Application No: A/253/21/OUT
Site Address: Land between 32 Downs Way and 2 Ambersham Crescent Angmering BN16 1AB
Description of works: Outline planning application with all matters reserved for the erection of 1 No bungalow dwelling with off street parking and private amenity space.

Thank you for your internet representation made on 26th January 2022 which has been recorded as an objection with the comments as follows:

Indicative Plans and Elevations

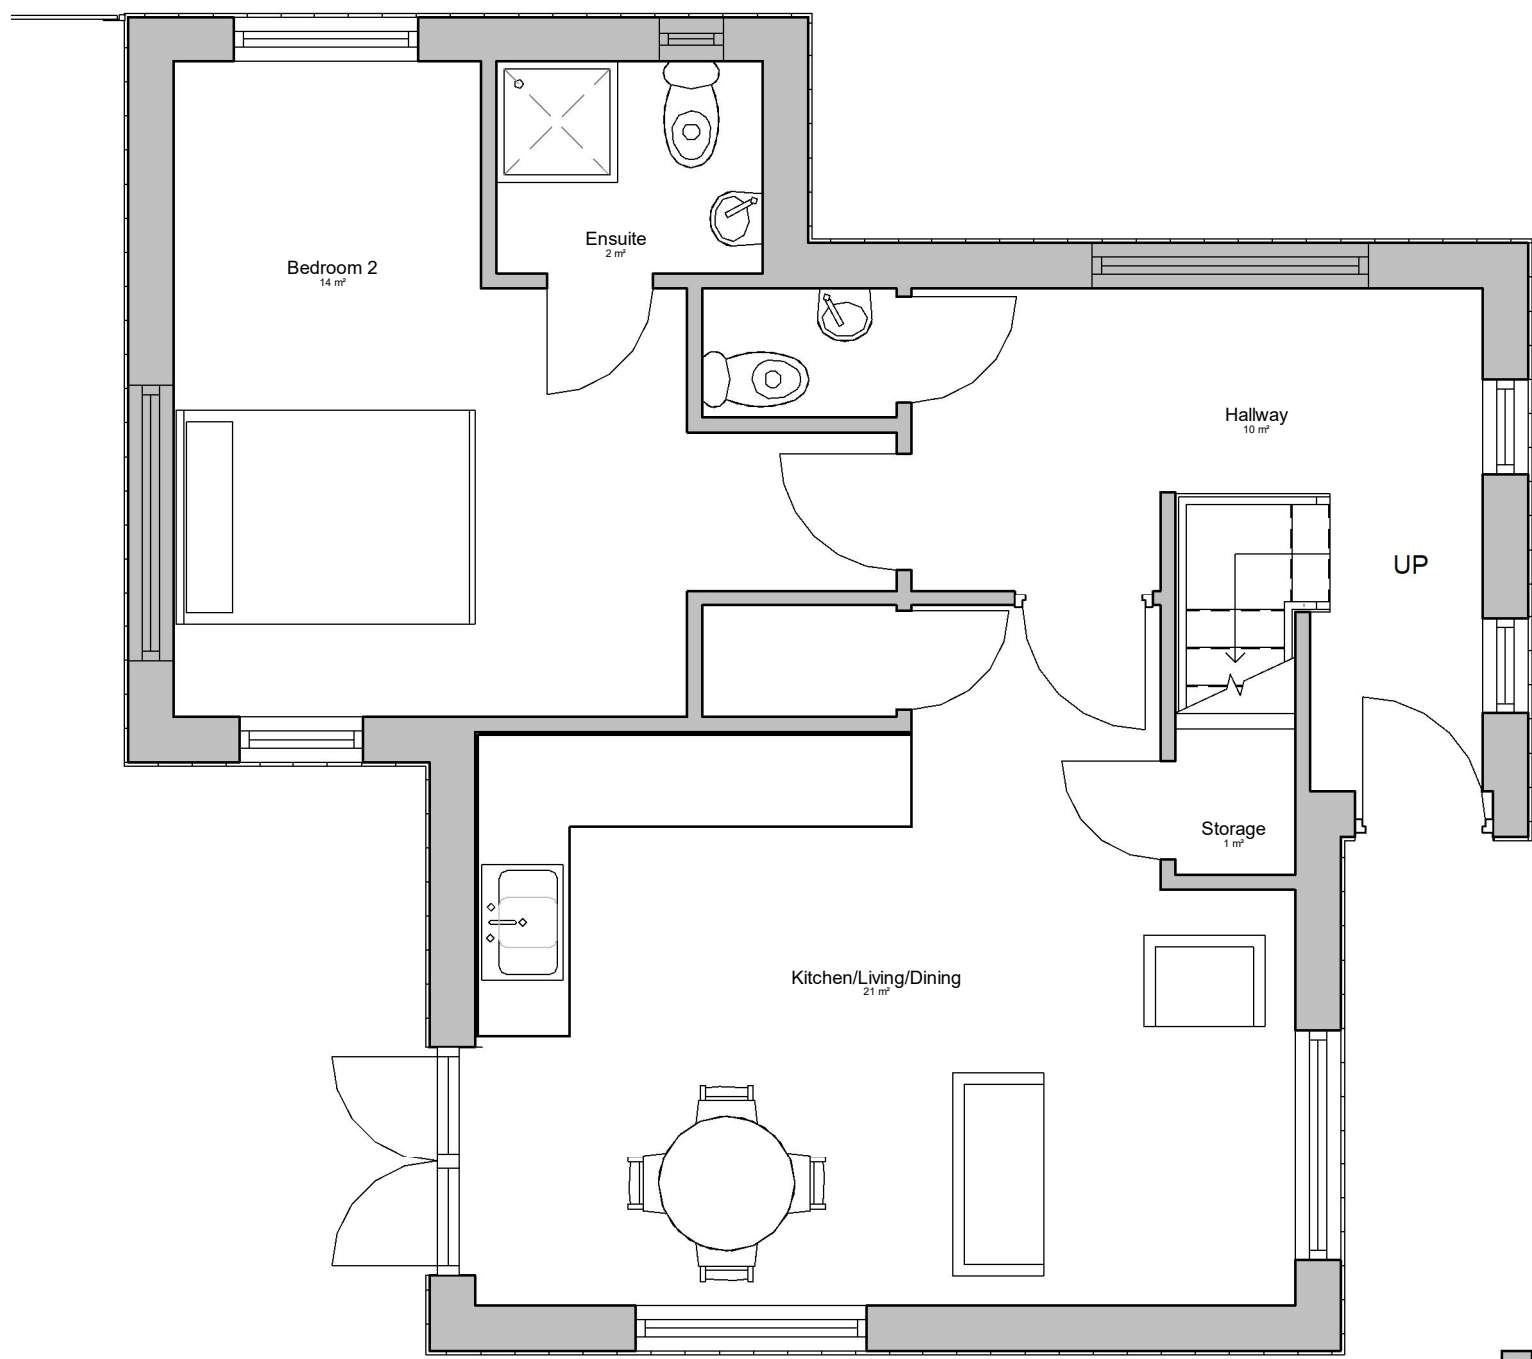
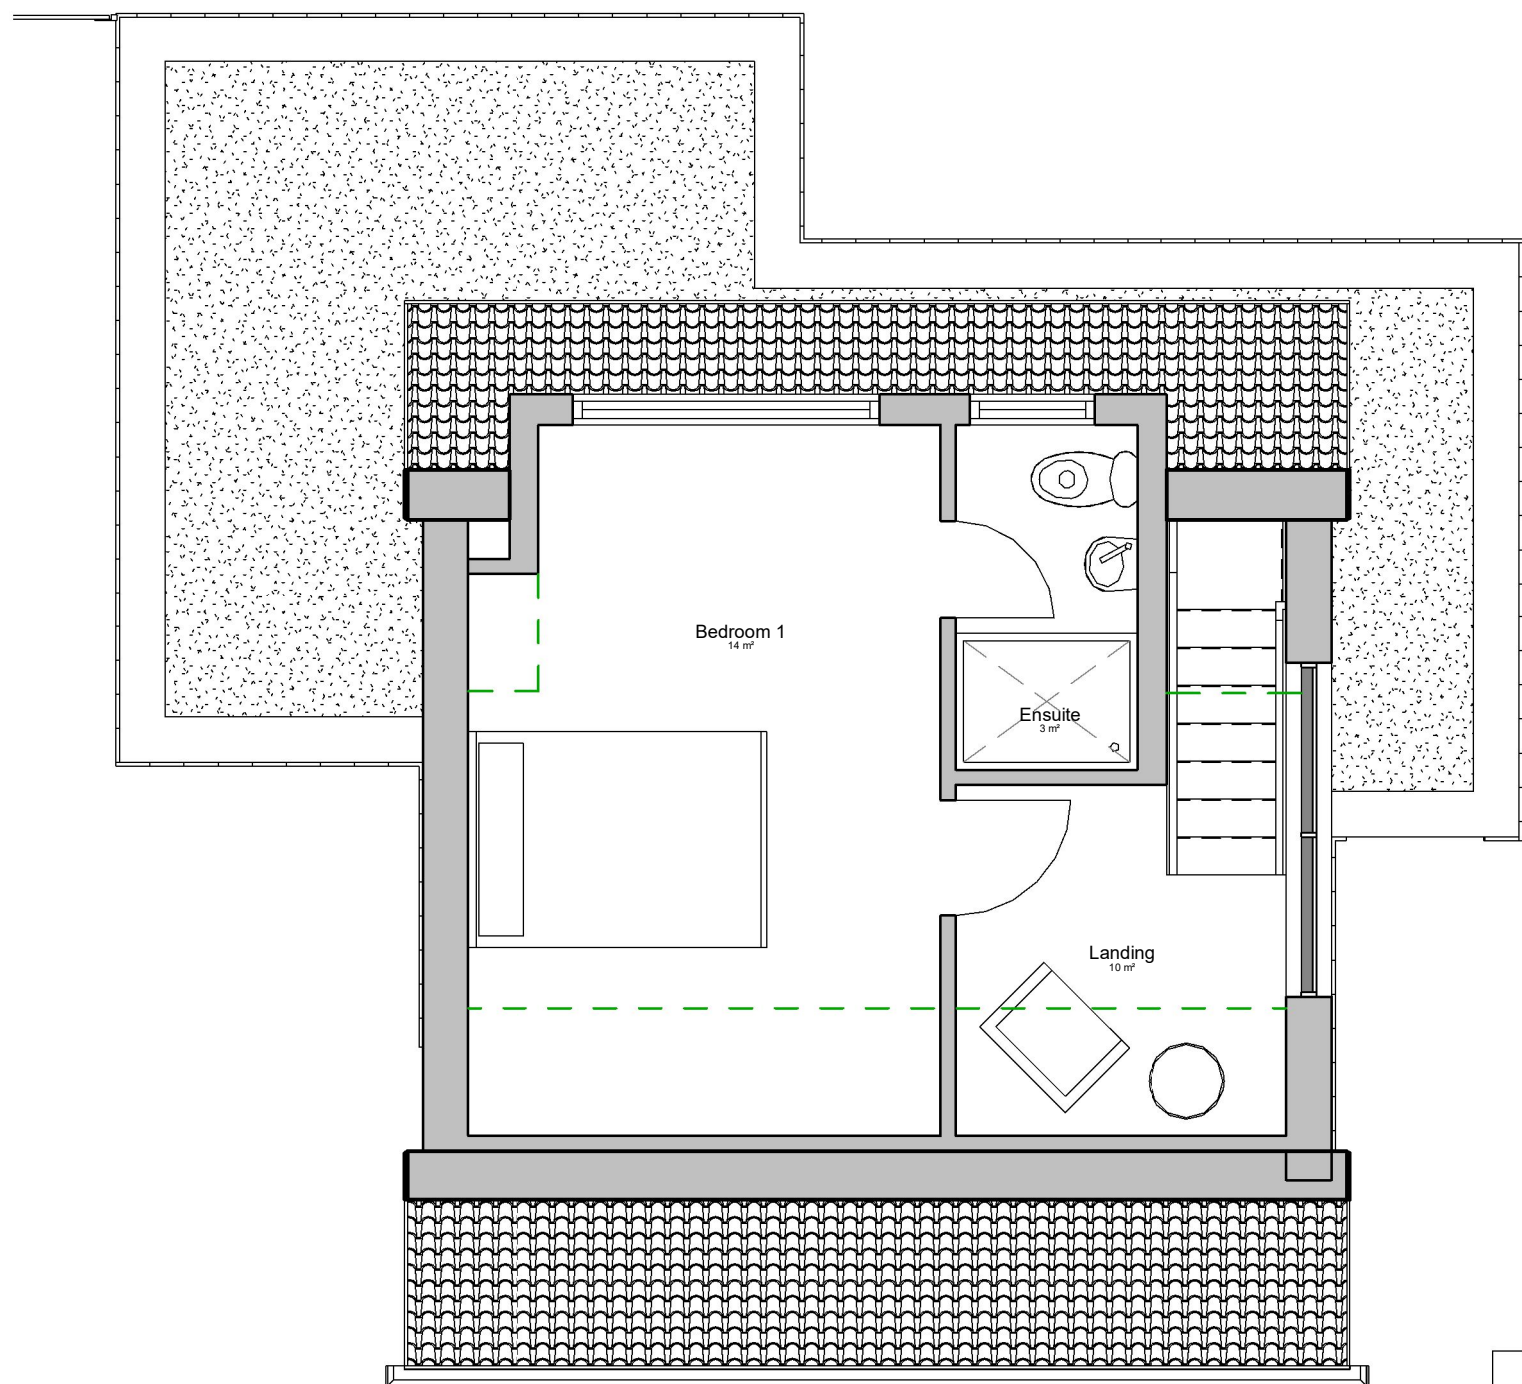
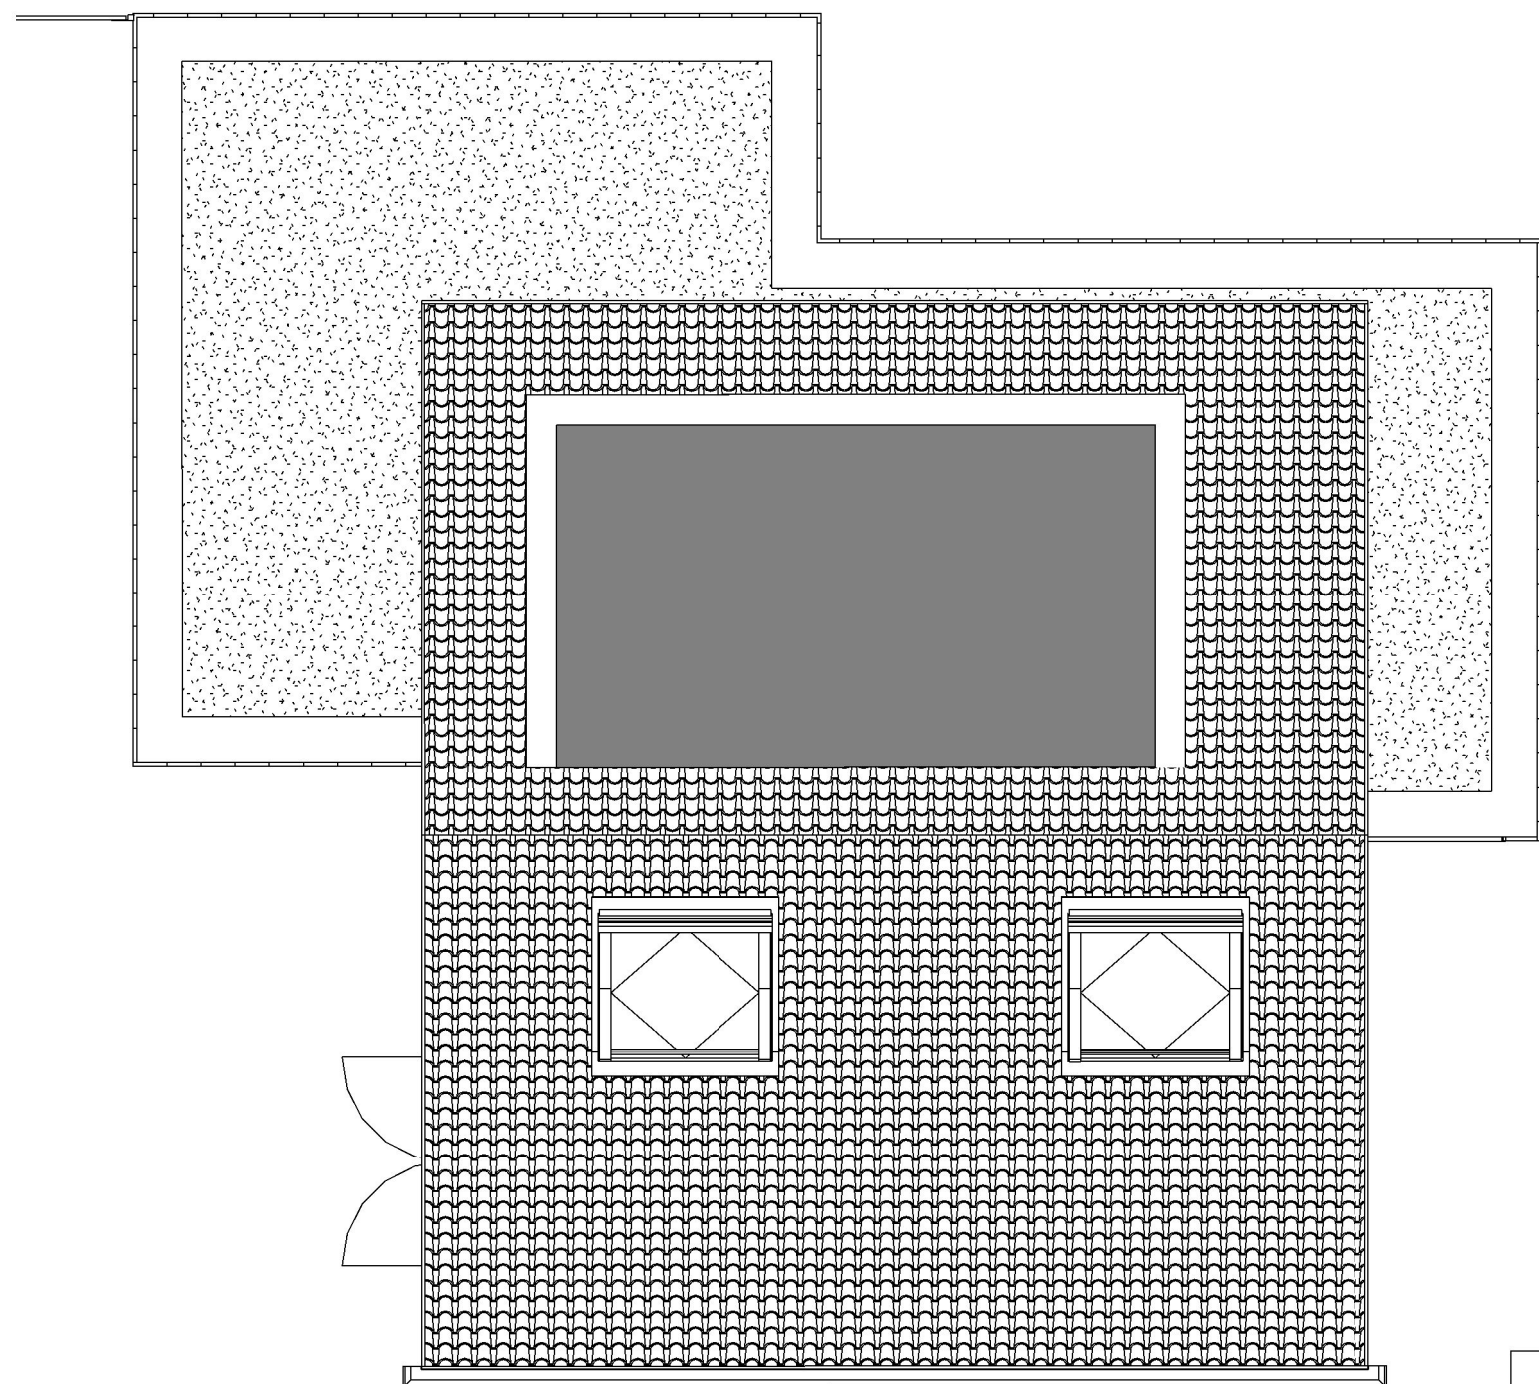
- Design
- The indicative layout plan submitted with the application shows a rear garden of no more than 2 metres and far too small for the development. If the house was brought forward to provide a longer garden it would sit far forward of the building line on Downs Way. If the rear garden was kept as shown, the occupier would have no decent sized secure space so would probably want to erect a tall fence around the front garden instead. That would be completely out of keeping and would potentially affect the visibility of cars pulling out of Ambersham Crescent onto Downs Way.

- The design hints at Velux windows on the south side of the pitch roof, which would directly overlook my rear garden and windows of my property.
- Light

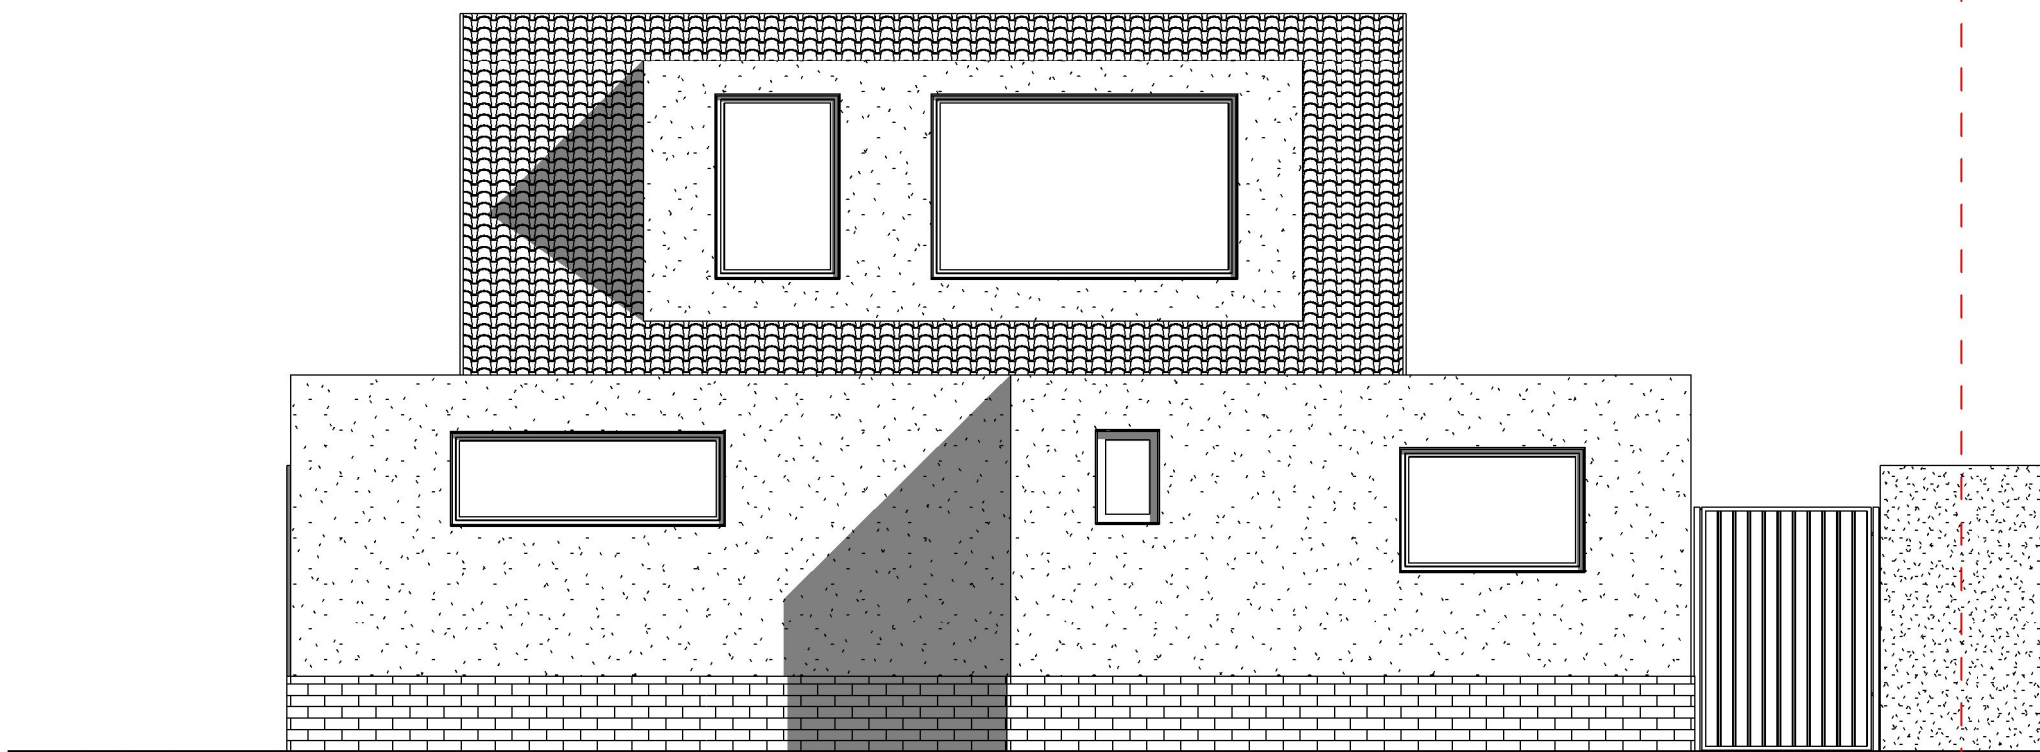
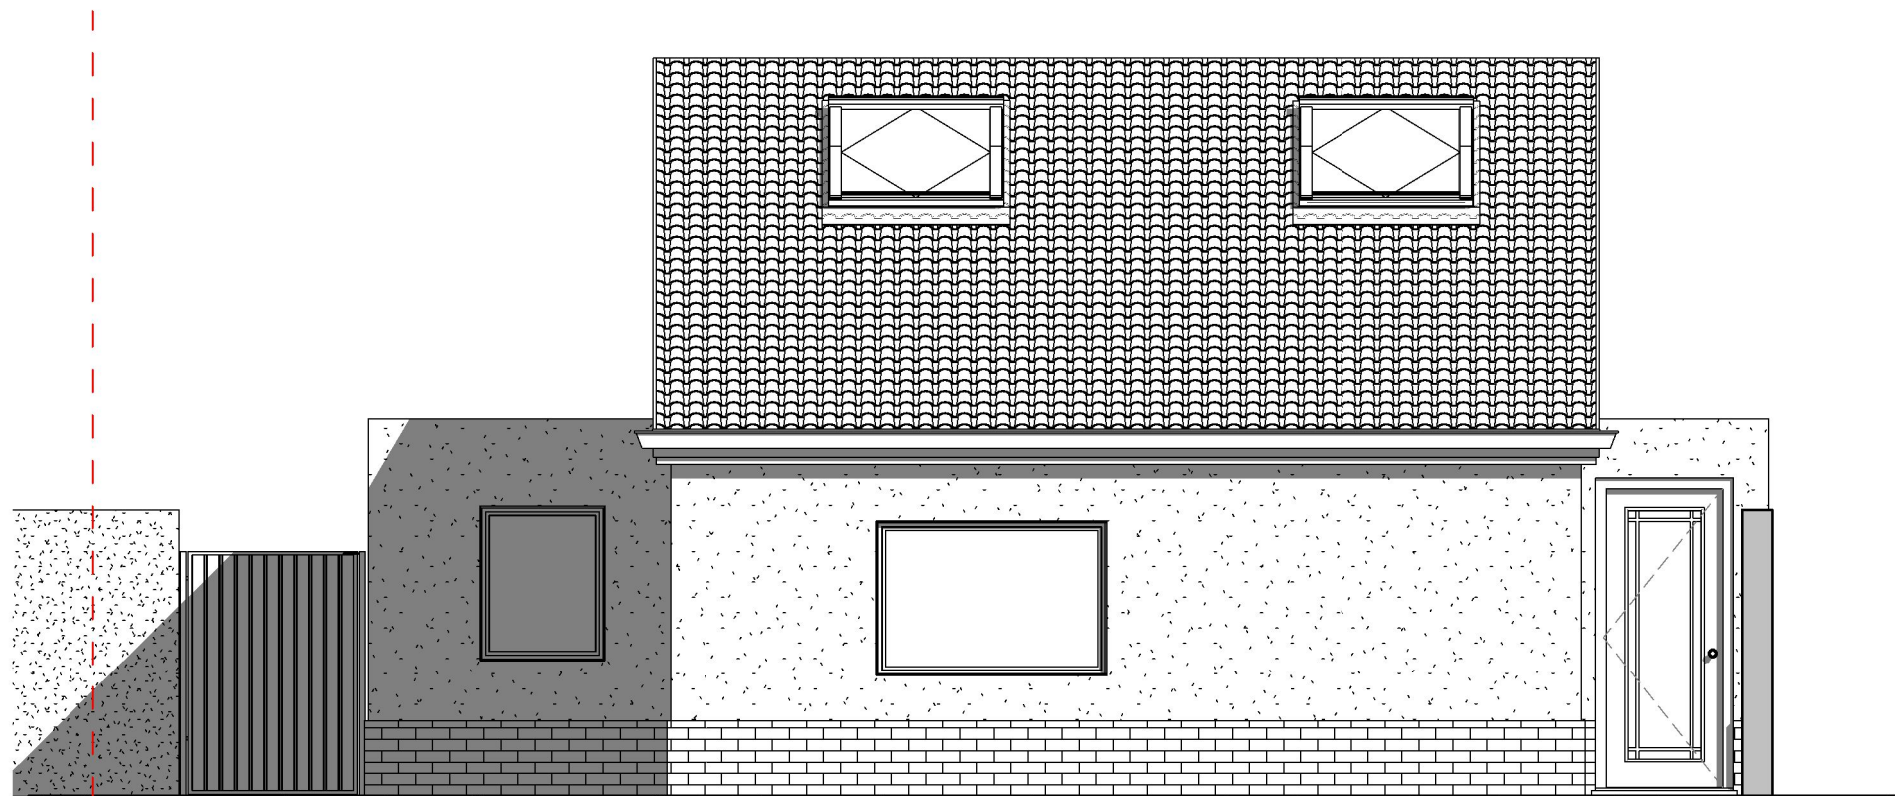
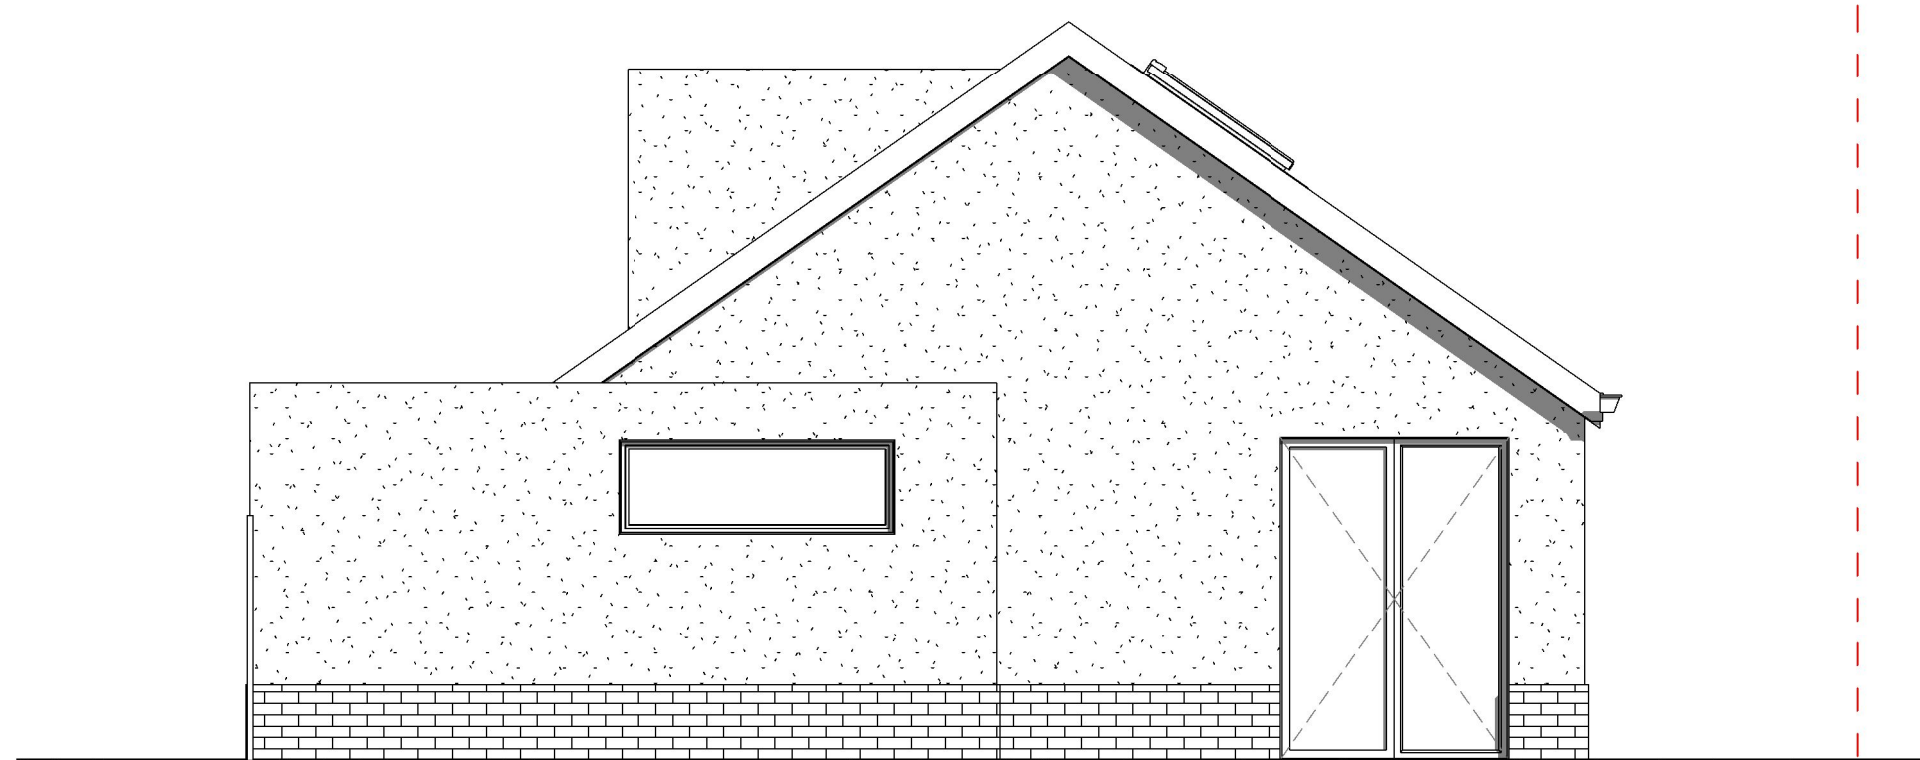
- The flat roof, two storey height of the house and window in the gable end is completely out of keeping with surrounding bungalows.
- Access to my driveway
